## **Gatwick Airport Northern Runway Project**

Planning Inspectorate's Reference: TR020005

### **Issue Specific Hearing 4: Surface Transport Post Hearing Submission**

**Issue Specific Hearing 4 (“ISH4”) on Surface Transport – 05 March 2024**

Diagram 2.3.1: Model extent and key junctions

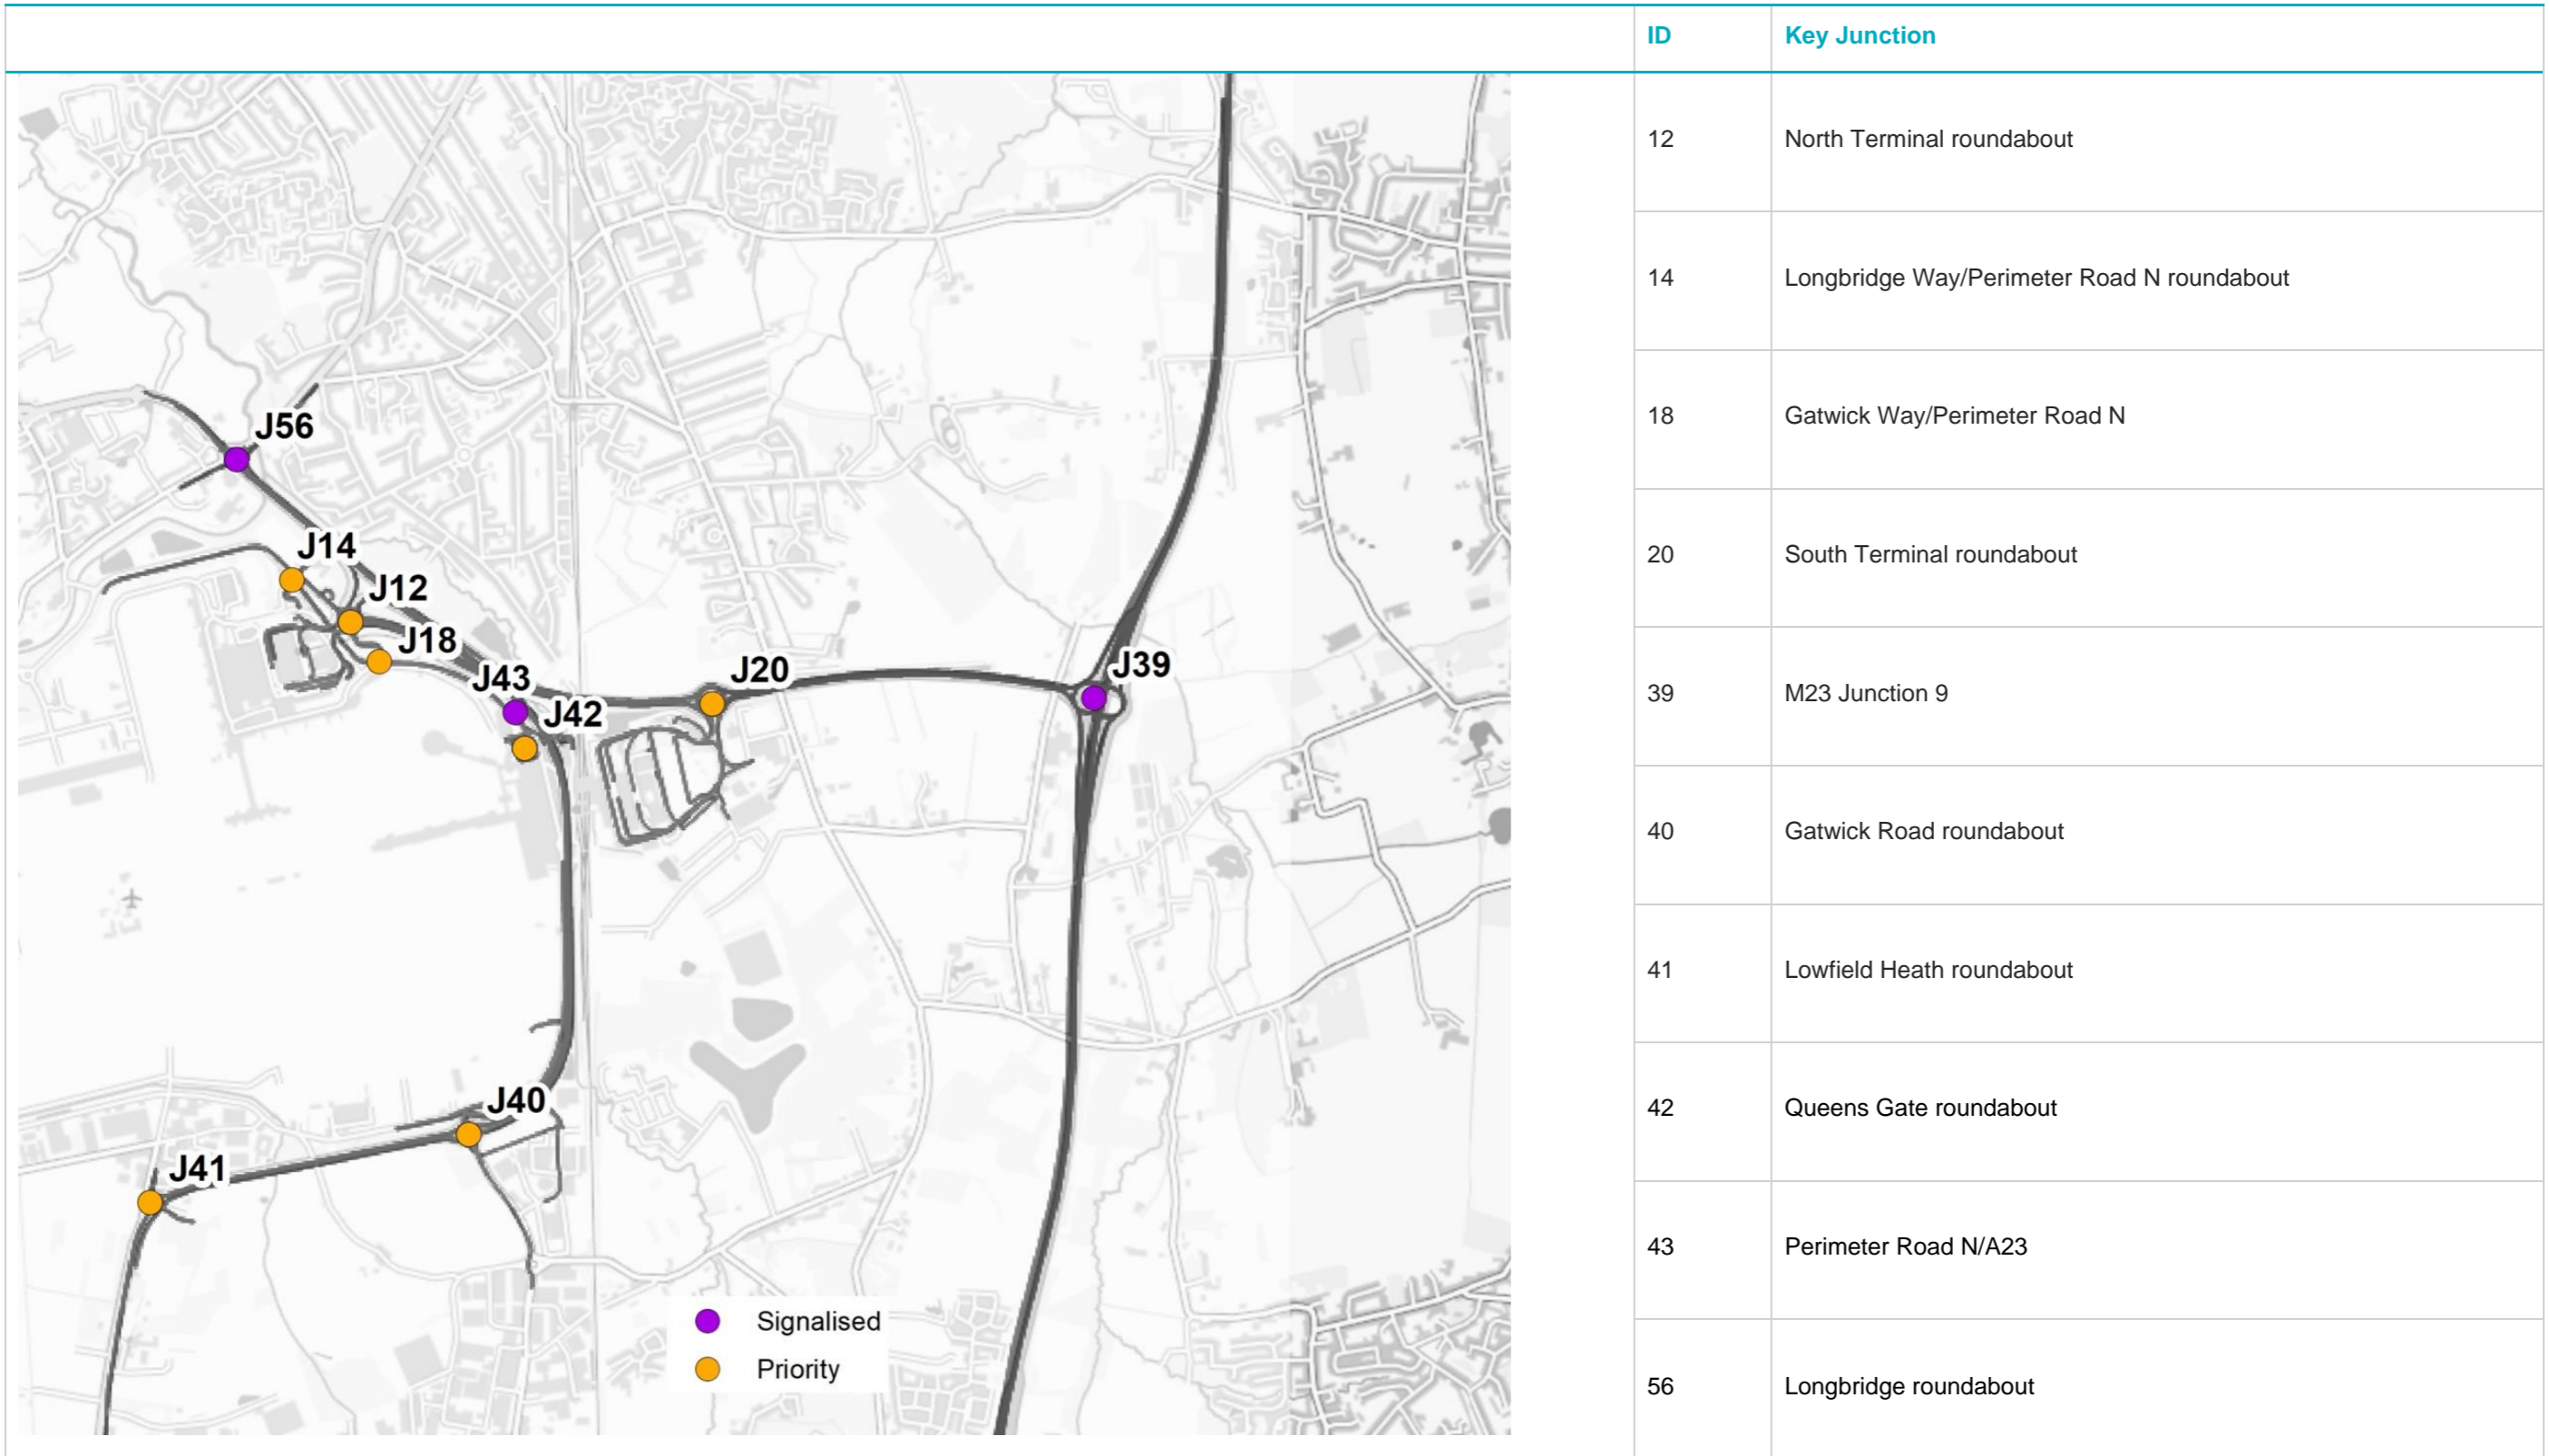
The extent of the Vissim model is shown on diagram 13 .4.1 of the Transport Assessment. The Longbridge roundabout sits towards the edge of that model network but what is not modelled are the interactions with the junctions that then feed in traffic to that roundabout. The Authorities are concerned the Vissim modelling is not necessarily picking up what is actually happening at that junction, because the Applicant has not modelled the interactions with the next junctions along the line. The Authorities have a concern with that and consider it is capable of being addressed by the Applicant and would urge the Applicant to give that some further consideration.

In view of these considerations, Surrey County Council requests that the VISSIM model include, at the very least:

- A23/Massetts Road;
- A23/Victoria Road;
- A217/Tesco roundabout; and
- A217/Hookwood Roundabout
